**CITY OF PORTLAND**

August 22, 2001

RE: 29 Hall Street: Fill Permit Application  
(#2001-0180) (CBL 159 A001001)

29 HALL ST
PORTLAND, ME

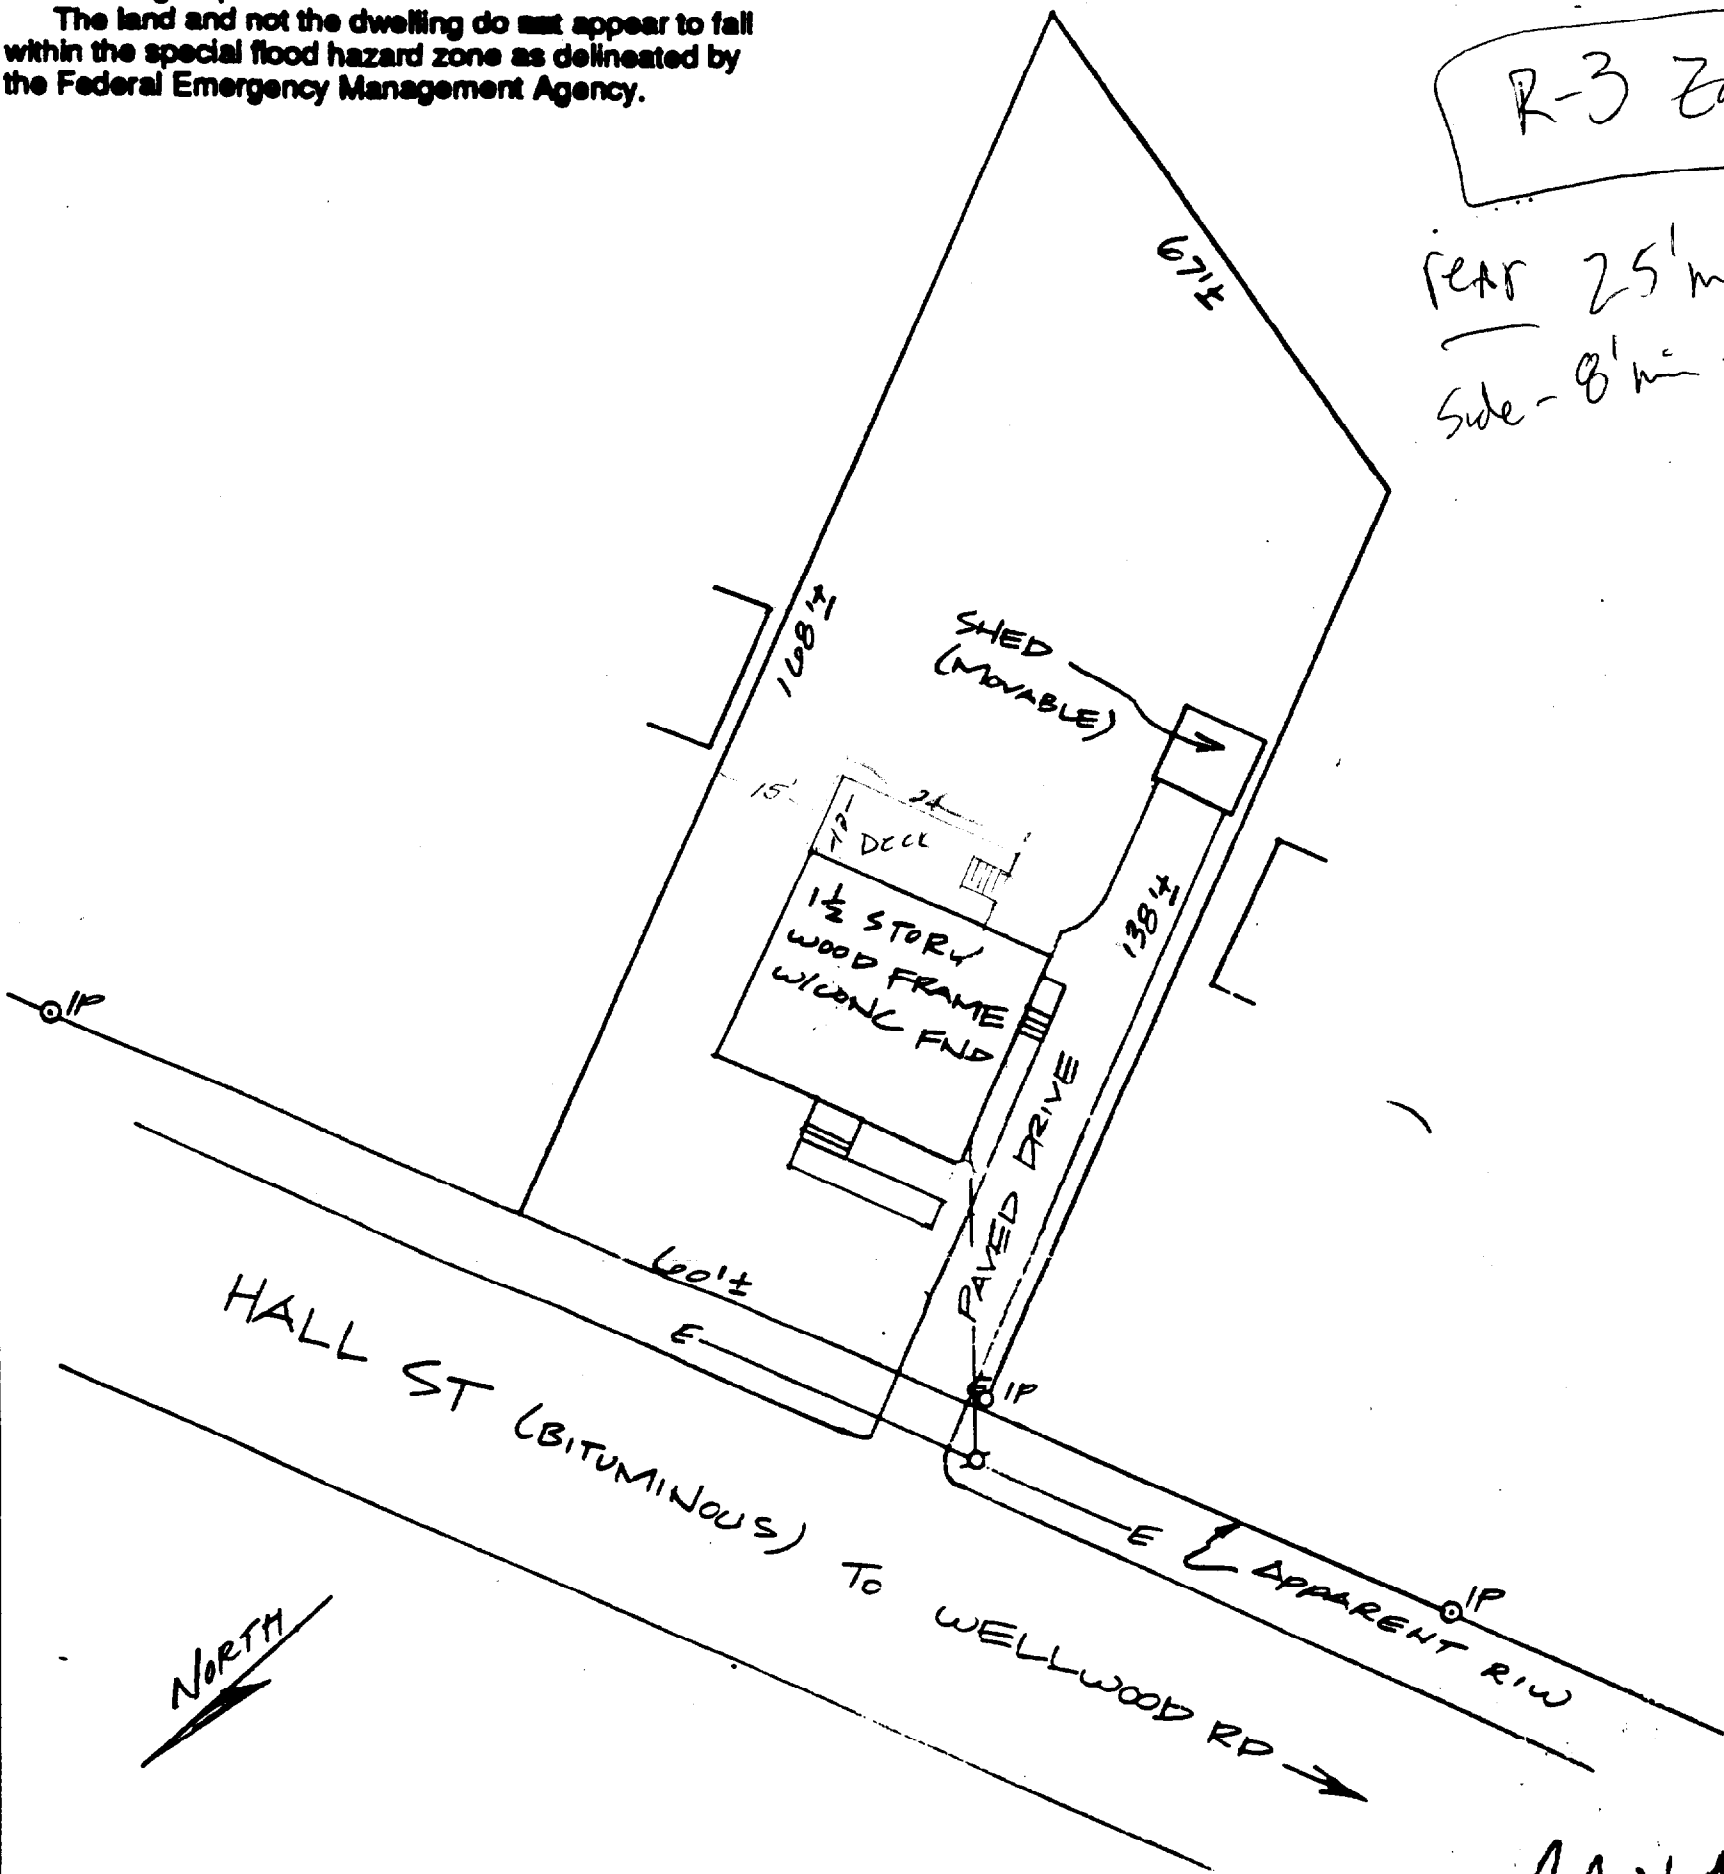
Your prior and proposed fill area is in a wetland area, and also infringes on the Fall Brook floodplain as shown on the Federal FIRM maps.

Your 1994 fill permit did not permit you to fill or alter wetlands and/or floodplains. As a result of the above facts, the city is denying your application.
